**Consultation Response from KC,
Lead Local Flood Authority**

2024/92842 Land to North and South of, Crossley Lane, Dalton, Huddersfield, HD5 0QP

Discharge of details reserved by conditions 3 (drainage) and 4 (adoptable estate roads) of previous Reserved Matters approval 2020/90805 pursuant to outline permission 2015/90430 for erection of residential development comprising (Use Class C3) and incorporating associated new access (to Crossley Lane and Cold Royd Lane) and associated works (122 dwellings)

Condition 3 – Drainage Details

MH S42 PLAN (1:20)

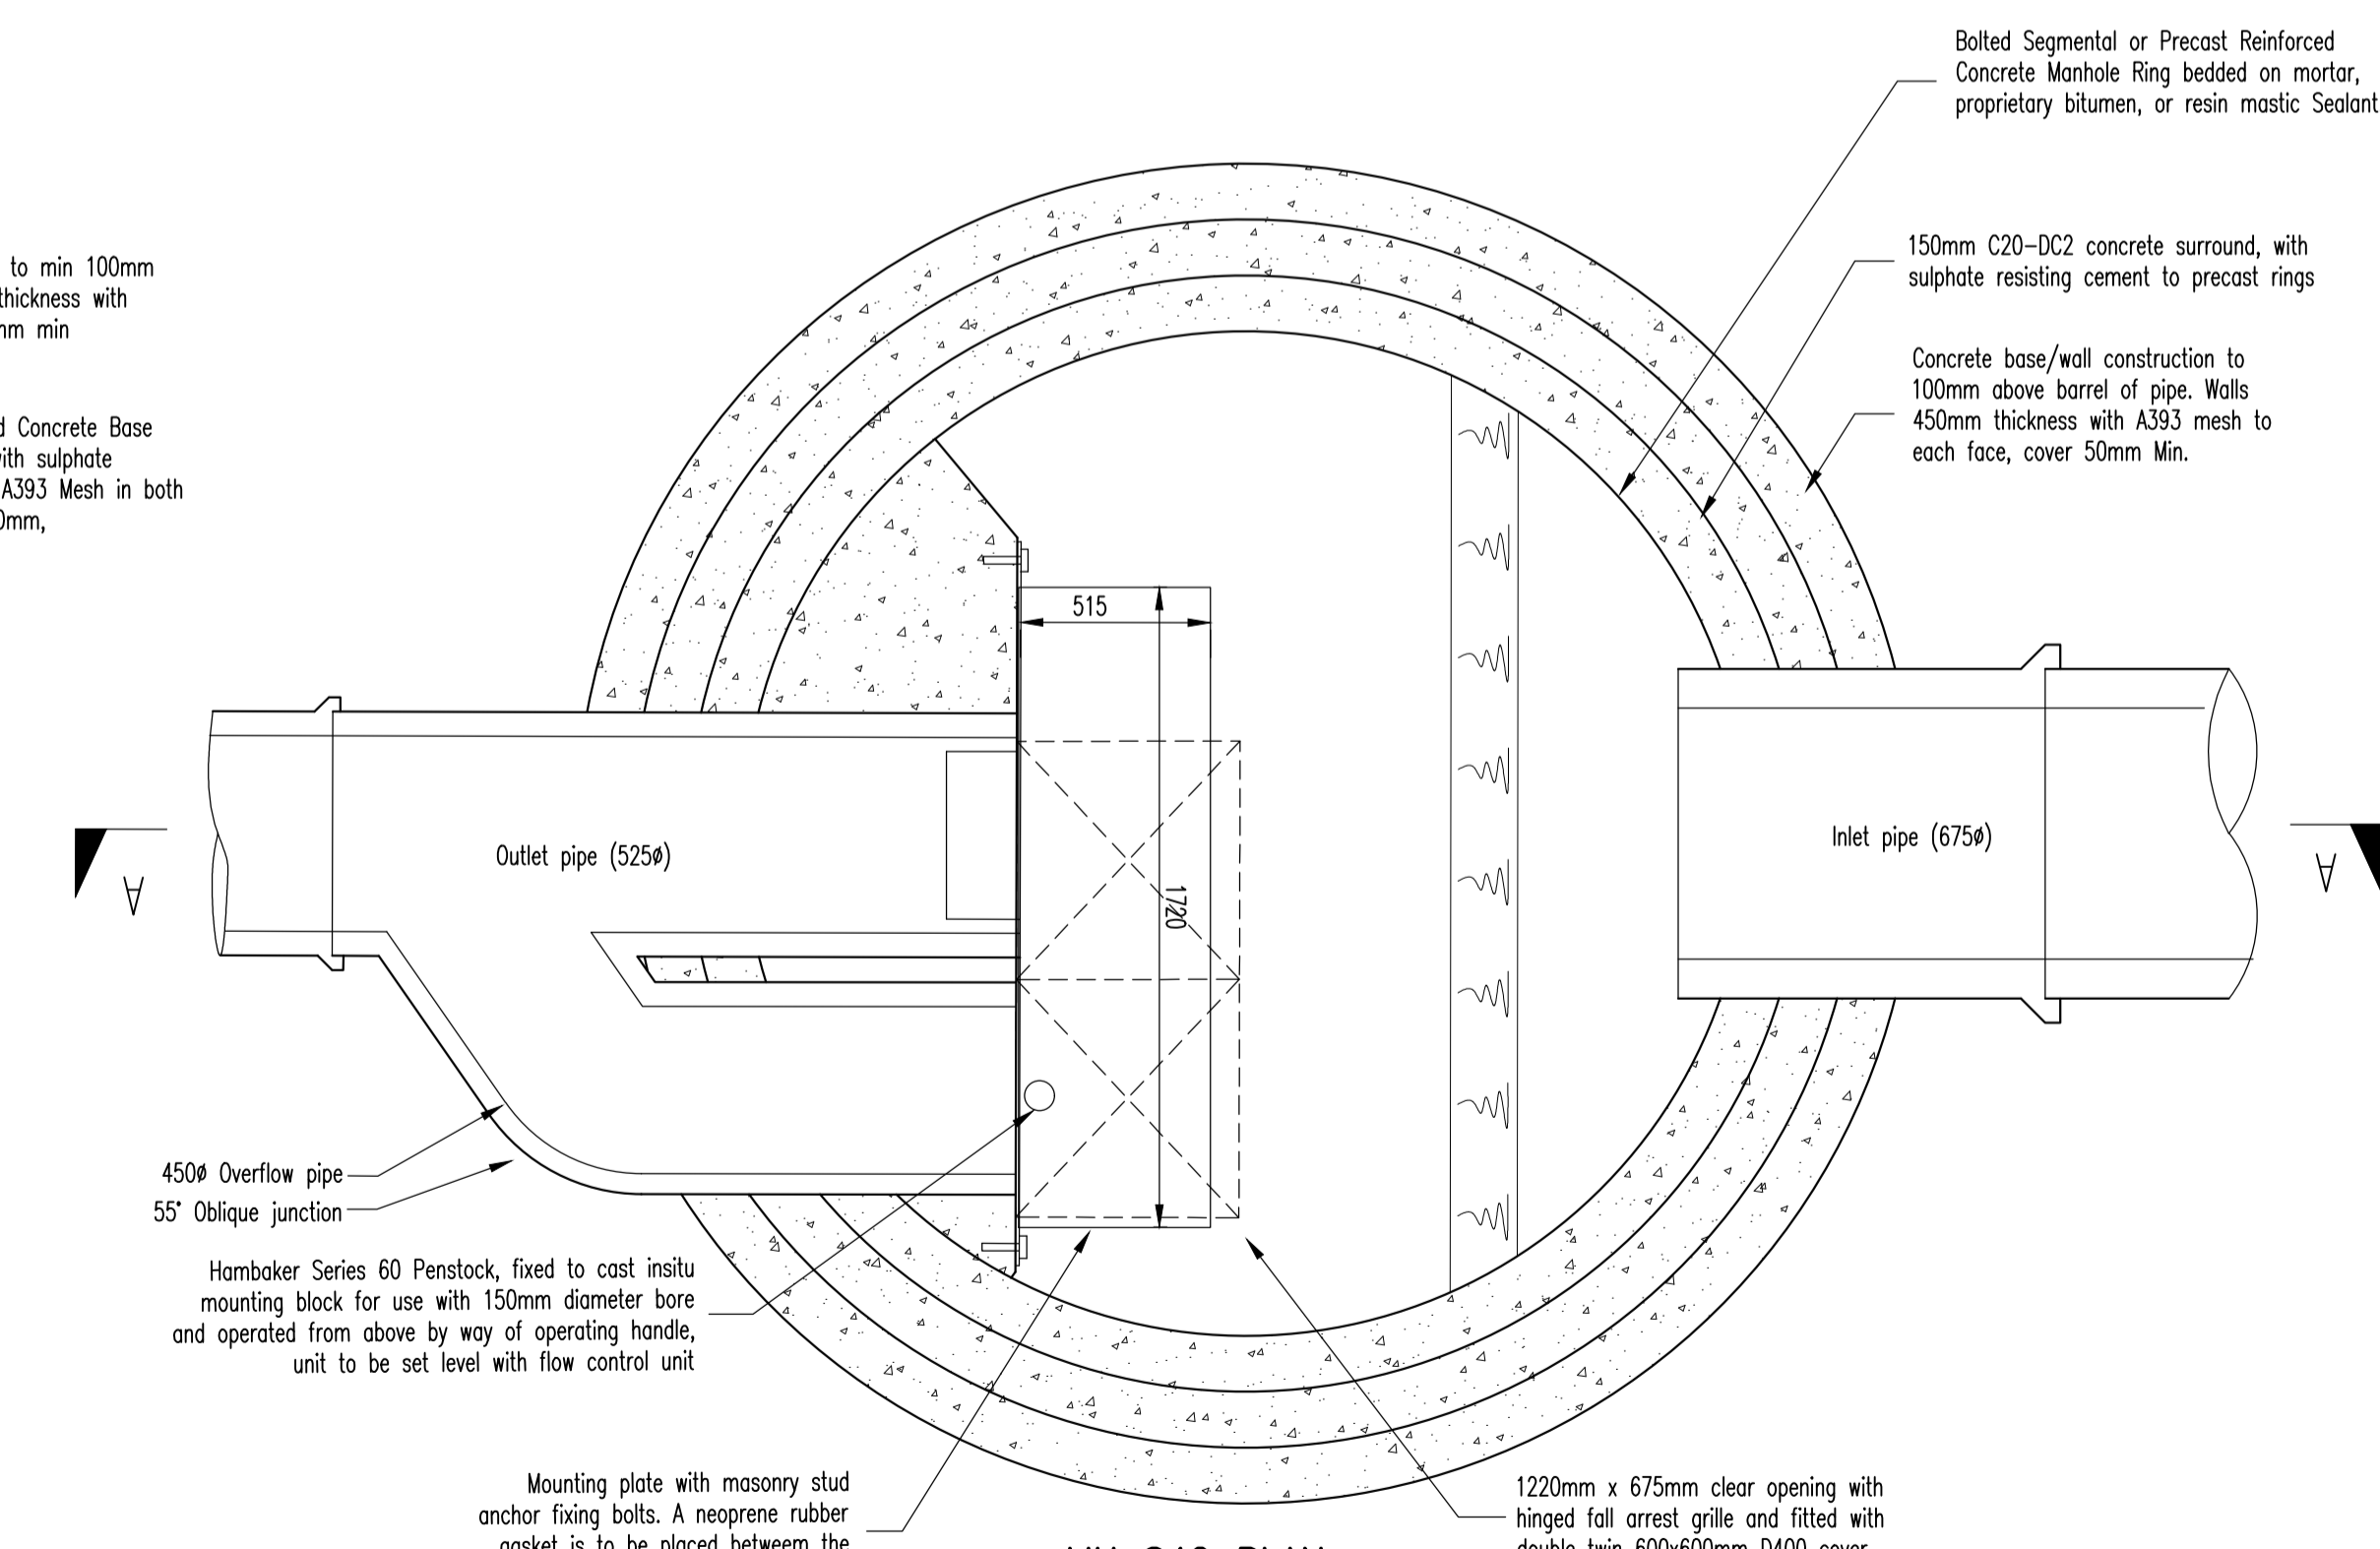
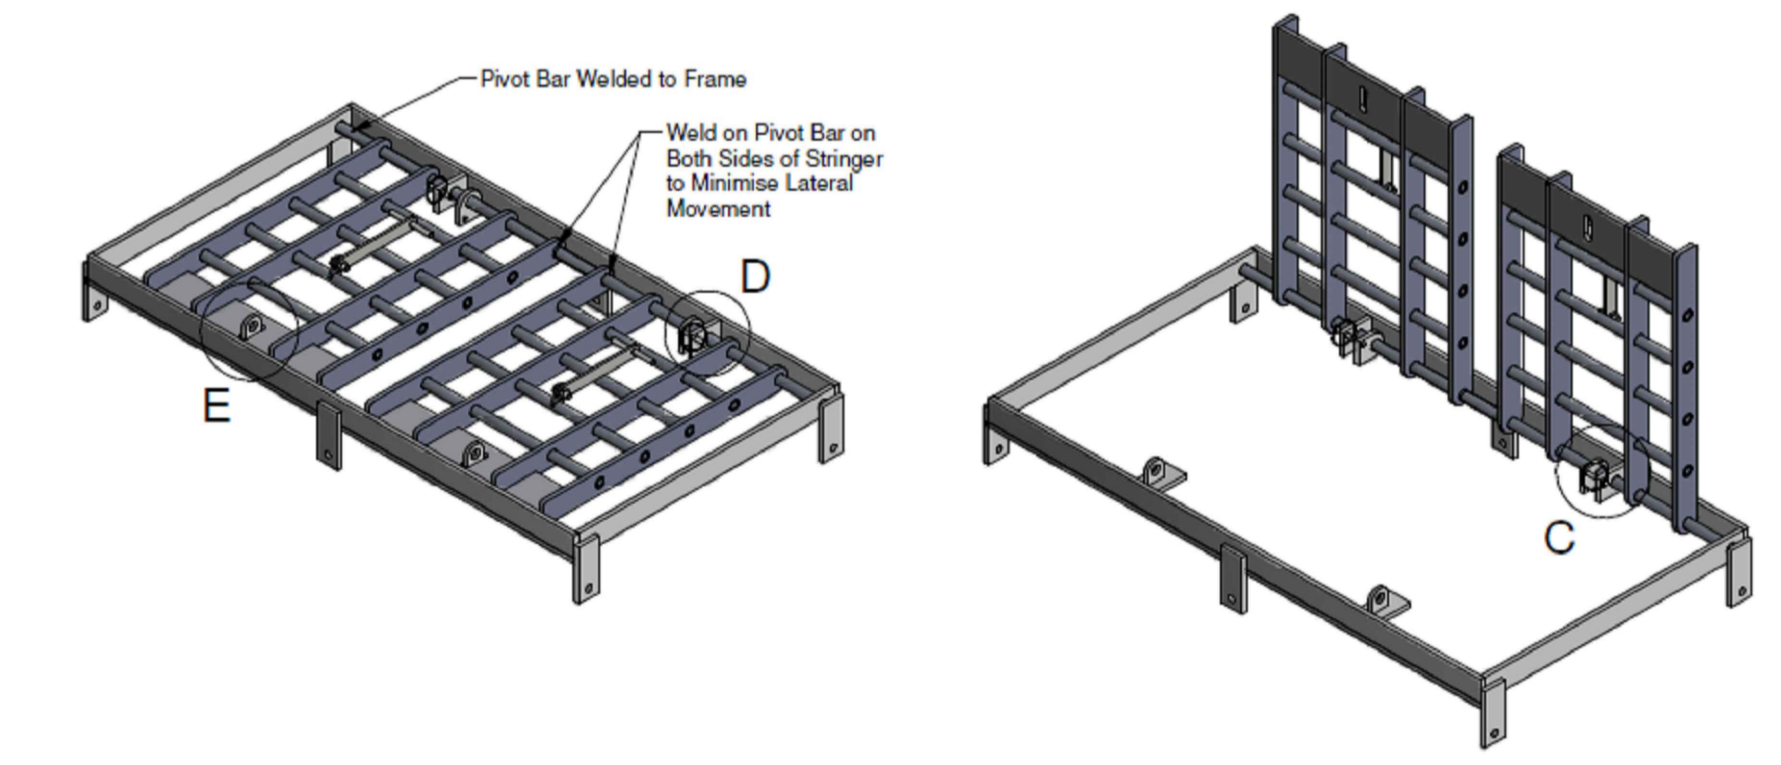
It is noted that the flow control device is large with of 1.51m. The double opening 1200 x 600mm cover is therefore inadequate should this need to be removed as part of maintenance and management of the surface water network.

Please show the configuration of manhole 21 with the orifice plate. Depth of water in the 1 in 1 in 30 and 1 in 100 +cc should be shown alongside calculations for the pass on flow at this height depth ratio.

**BASE PLAN: 1.8m Deep Modular Tank**  
Estimated Storage Volume: 702m<sup>3</sup>

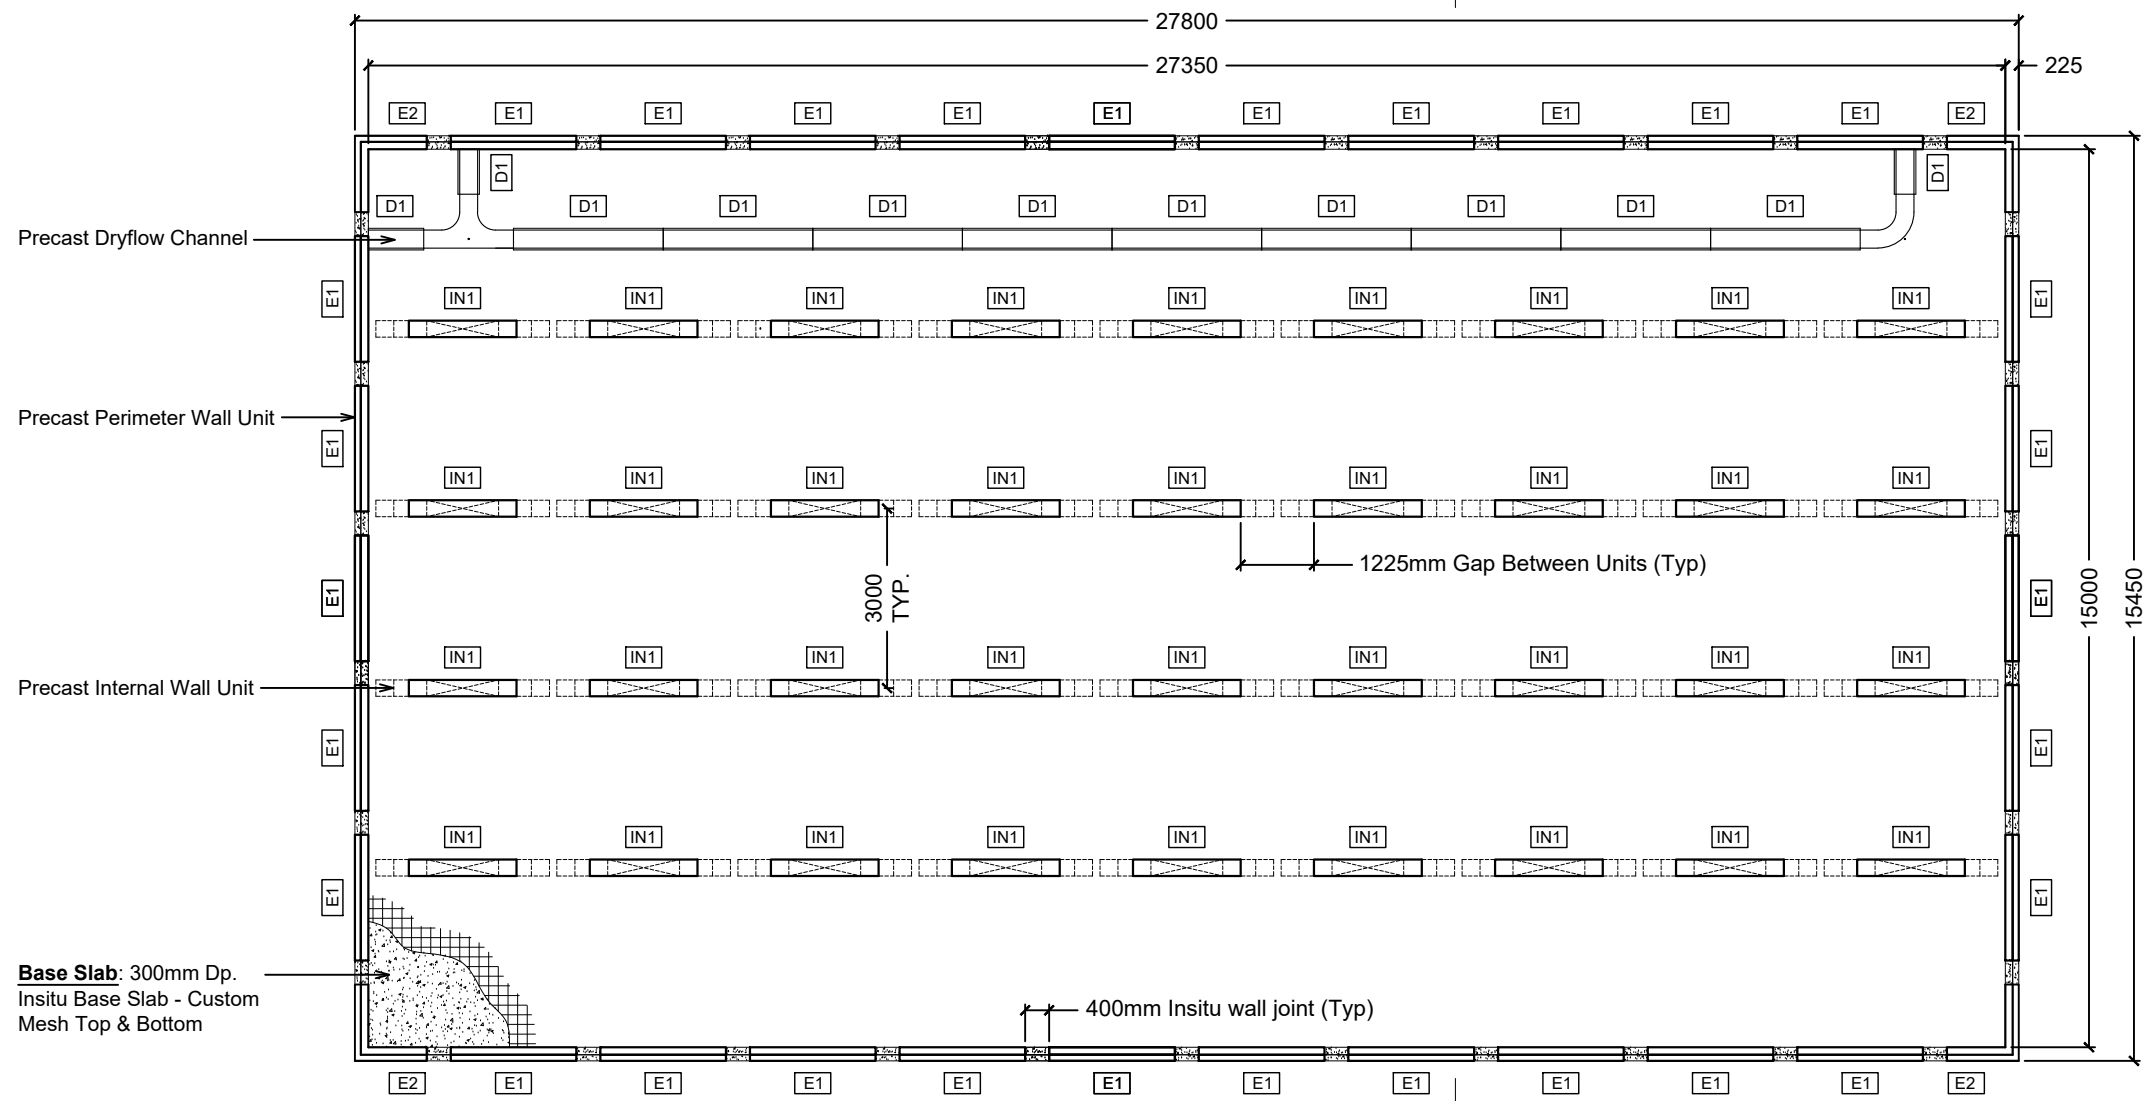
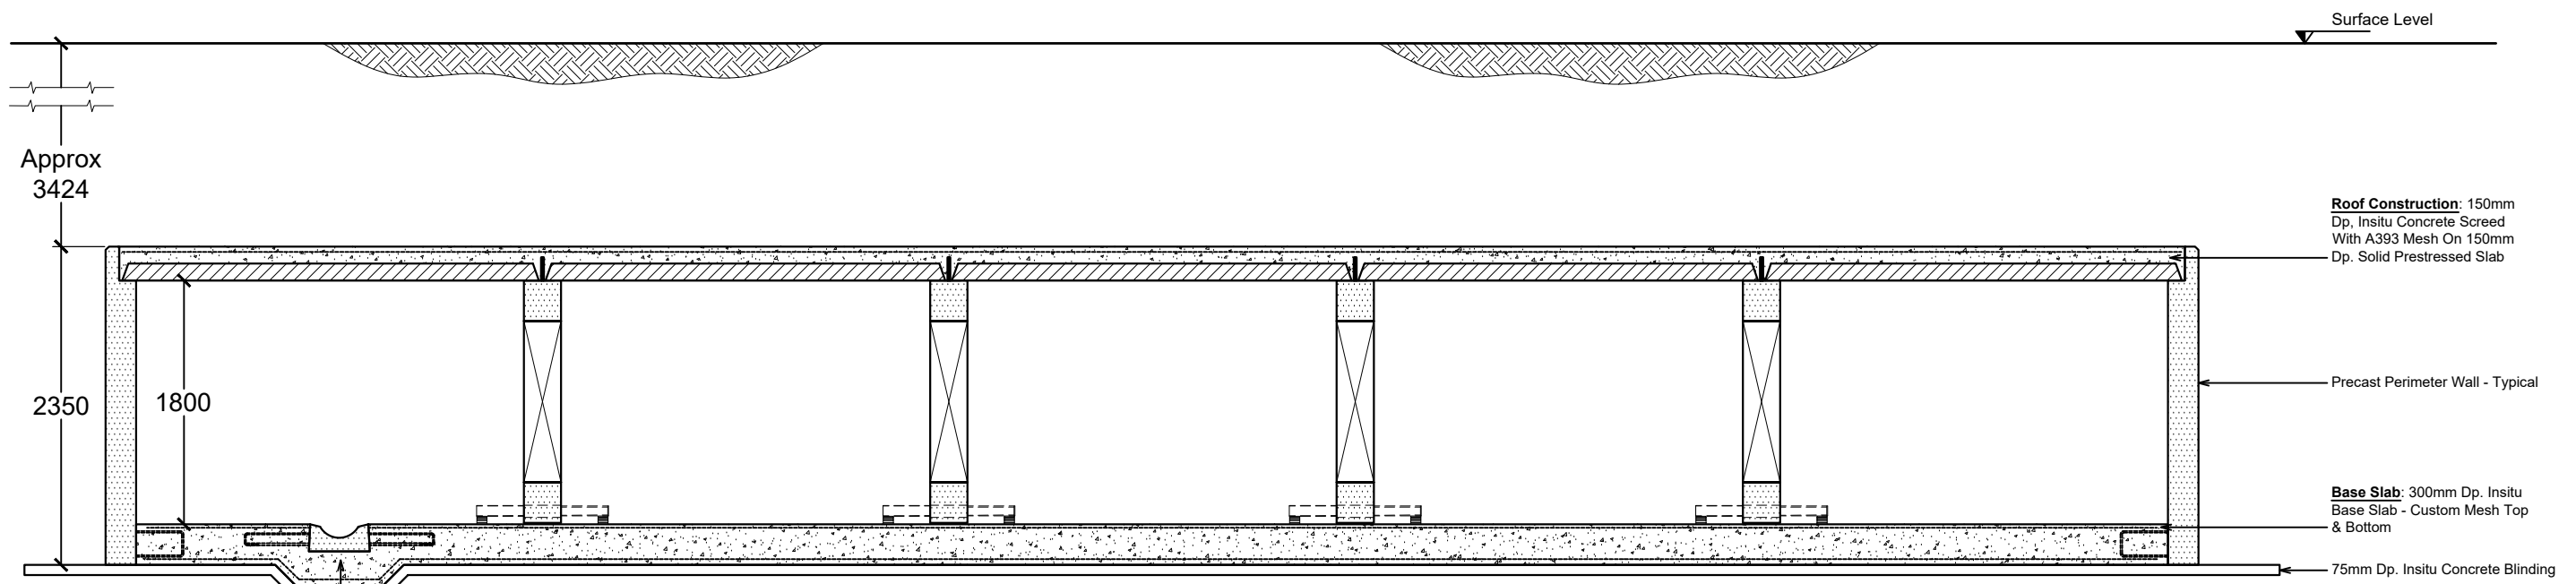
A plan and cross section of the tank has been supplied noting a volume of 702 sqm. Calculations currently show $1.8 \times 350 \text{ sqm} = 630$ cubic metres.
